From: DFW R4Cplanning <R4Cplanning@dfw.wa.gov>
Sent: Tuesday, August 1, 2023 9:45 AM
To: Chris Holland
Cc: Lakey, Kirk A (DFW)
Subject: [External!]RE: Dell's Nursery Rezone - Notice of SEPA (PA22041)

Thank you for the opportunity to comment on this project (PA22041). Our comments are mostly for clarity:

Project Name: Dell's Nursery Rezone

Description: Site Plan Approval and Concurrent Rezone from Medium Density, Single-family (R-4.5) to General Commercial (GC) in order to construct two single story office/warehouse buildings totaling approximately 30,600 SF.

A PORTION OF SECTION 16, TOWNSHIP 30 NORTH, RANGE 05 EAST, W.M.

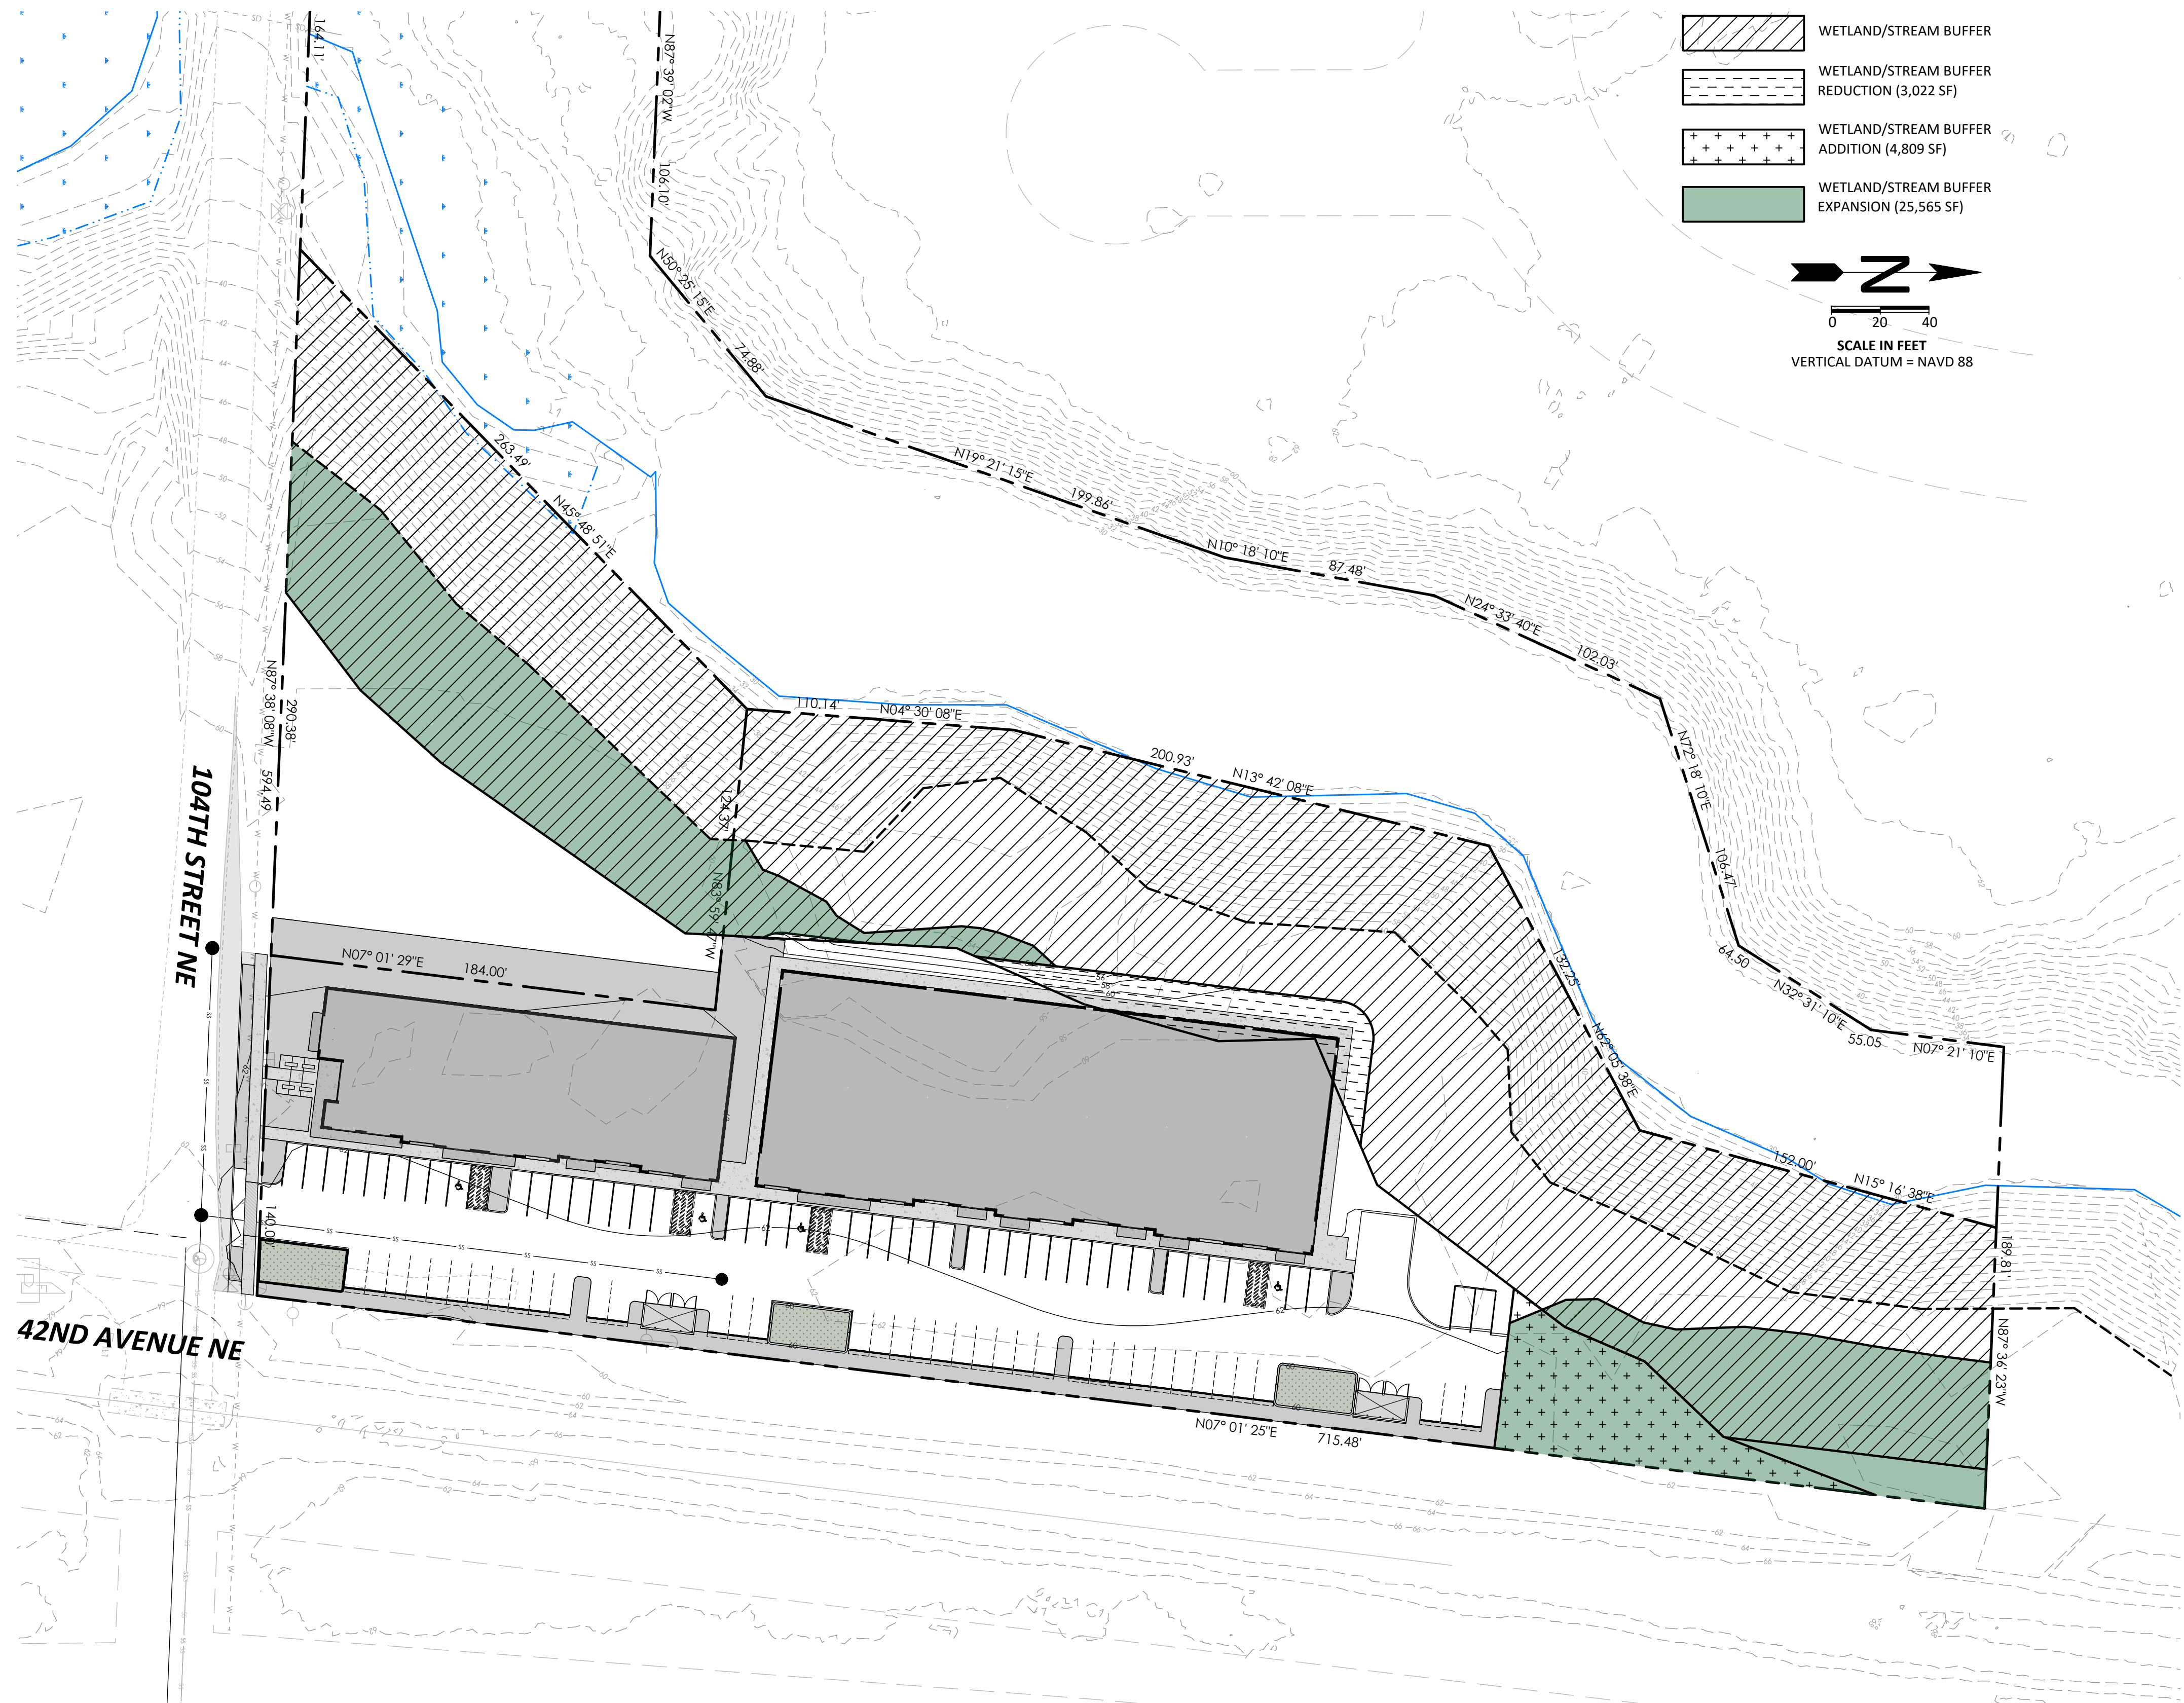
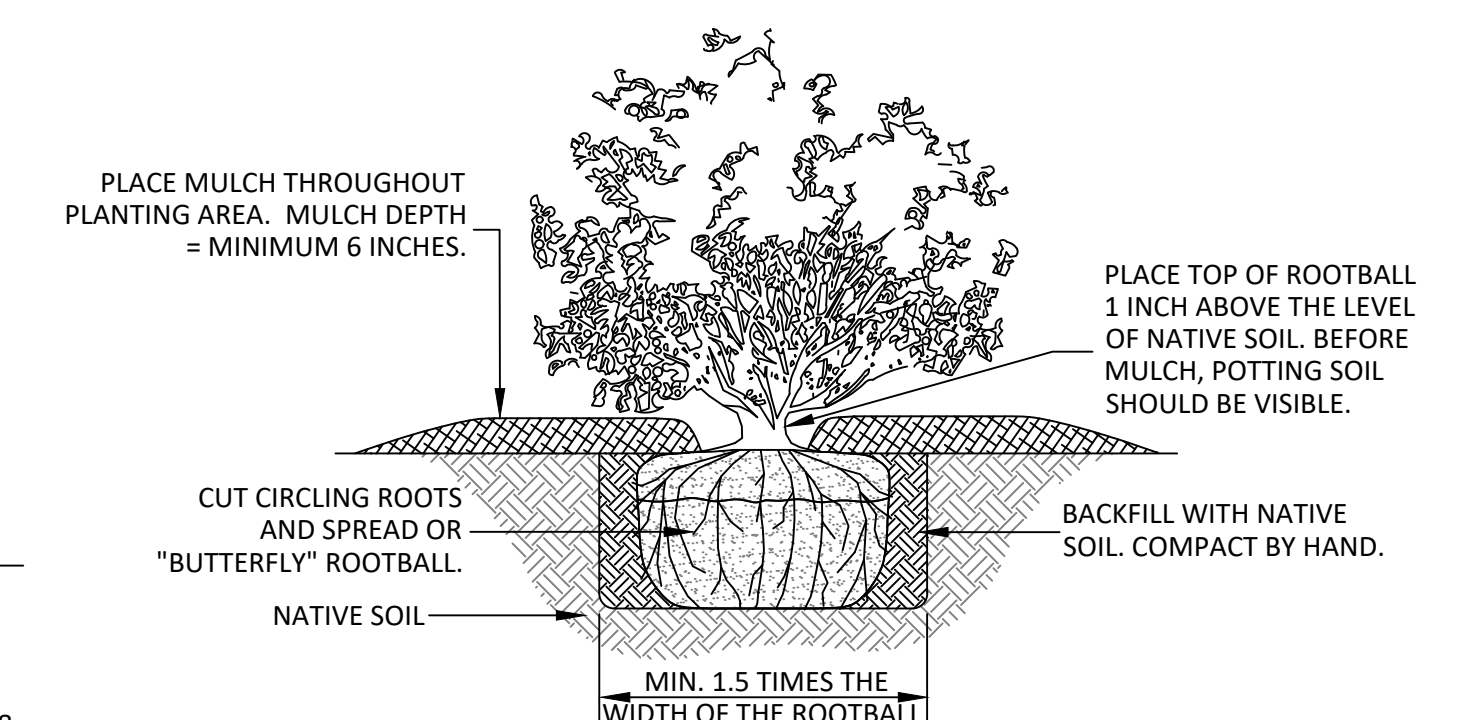
- On the landscape plan, the applicant does not seem to include their plans for the 'wetland buffer addition'. A clear plan outlining how this area will be restored and monitored is needed.

- It would be great if the maps provided could depict the pond feature. I'm having trouble visualizing how close the reduction in buffer is to the impounded area of water that is considered part of the wetland. I'm imaging the amount of water in this pond-like feature (very obvious on arial imagery) increases in the wet season, causing concern for flooding if the buffer is reduced close to this feature.

- When were the wetland boundaries surveyed? The information provided made this unclear. The ponded area could be much bigger if these measurements are taken from the 2006 survey...
